Appeal Decision

Appeal Ref: APP/R5510/D/25/3359028

130 The Fairway, Ruislip, HA4 0SH

- The appeal is made under section 78 of the Town and Country Planning Act 1990 (as amended) against a refusal to grant planning permission.
- The appeal is made by Gulraiz Ghafoor against the decision of the Council of the London Borough of Hillingdon.
- The application Ref is 67889/APP/2024/2455.
- The development proposed is a 5.5m rear extension with 2 roof lights (3m max height, 2.943m eaves height).

Proposed Ground Floor Plan

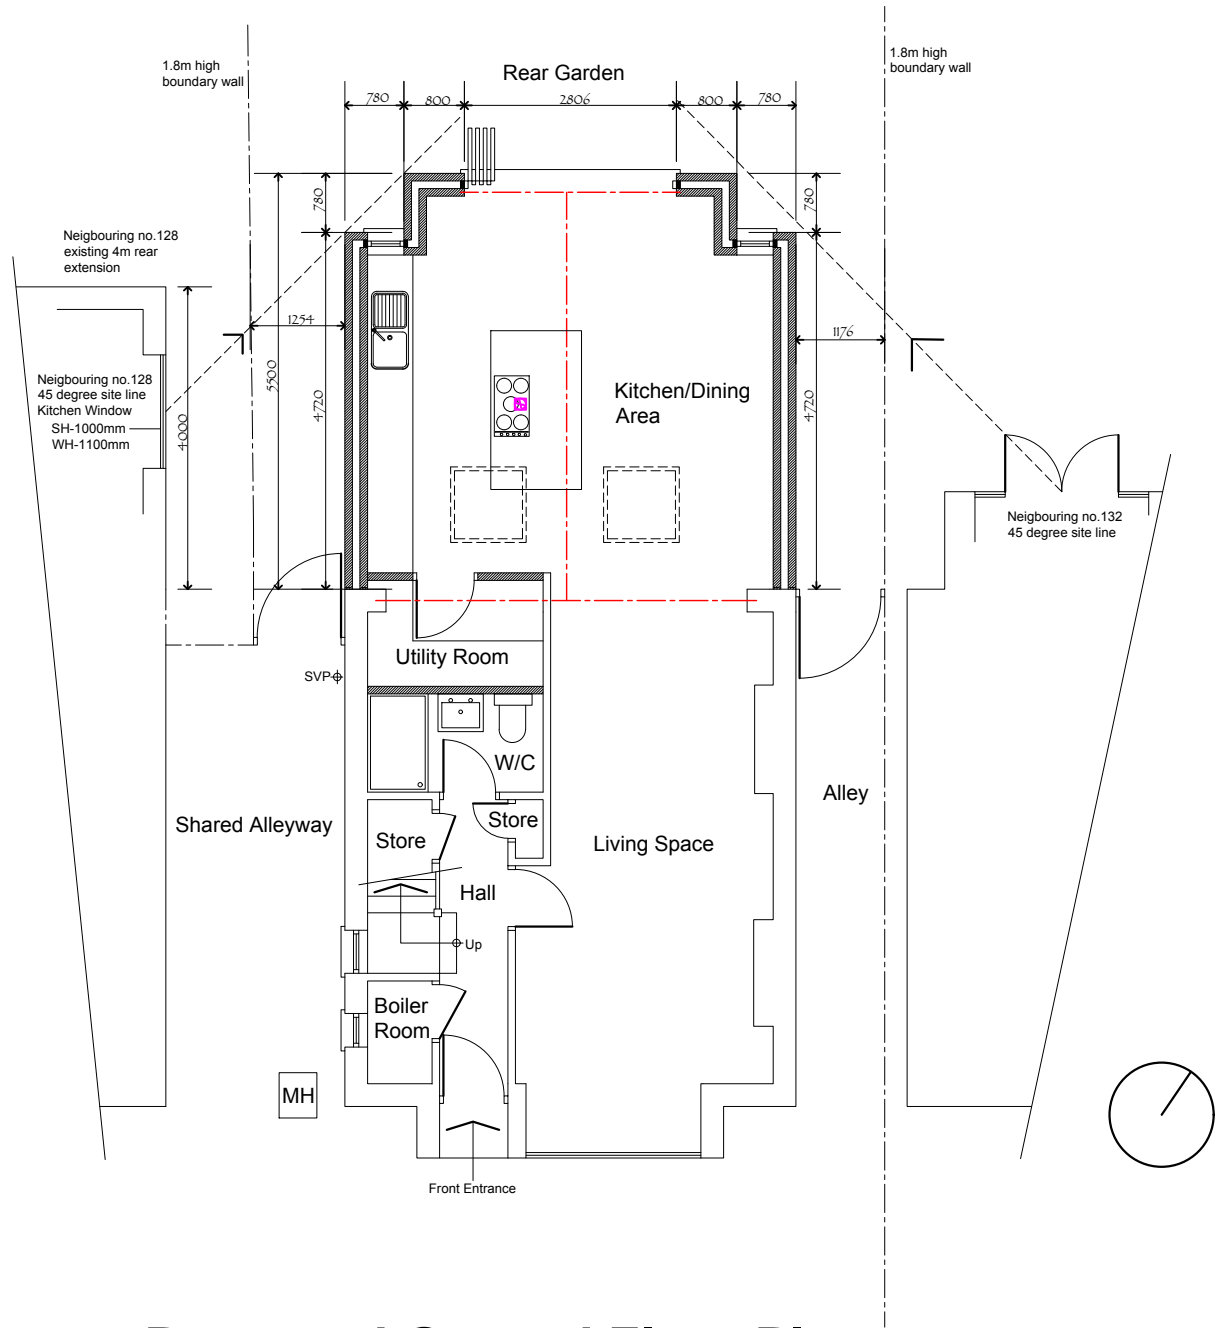
5. The proposed development would introduce a substantial rear, single-storey extension which would be of similar footprint to the existing host dwelling. Its design would be typical of other rear extensions on dwellings of The Fairway and East Mead, though would be larger in depth than many. However, due to its modest height, the massing of the proposed extension does not appear as a bulky nor dominating addition to the host dwelling. Therefore, whilst the proposed development would lack subservience in terms of its footprint, its overall relationship to the host dwelling would be subordinate and would not harm its character and appearance when seen from nearby and neighbouring properties on The Fairway and East Mead.

7. I acknowledge that the proposed development would not comply with the specific technicalities of subsection B(i) of policy DMHD1 (Alterations and Extensions to Residential Buildings), which sets out that the proposed development should not exceed 4 metres in depth in this context. However, for the reasons above, the proposed development would not have an adverse impact on the host property, wider area or street scene in terms of character and appearance. Consequently, the proposed development would comply with the overarching objectives of the policy which, amongst other things, aims to ensure that extensions to residential dwellings are appropriate to the local context and are subordinate to the host dwelling.
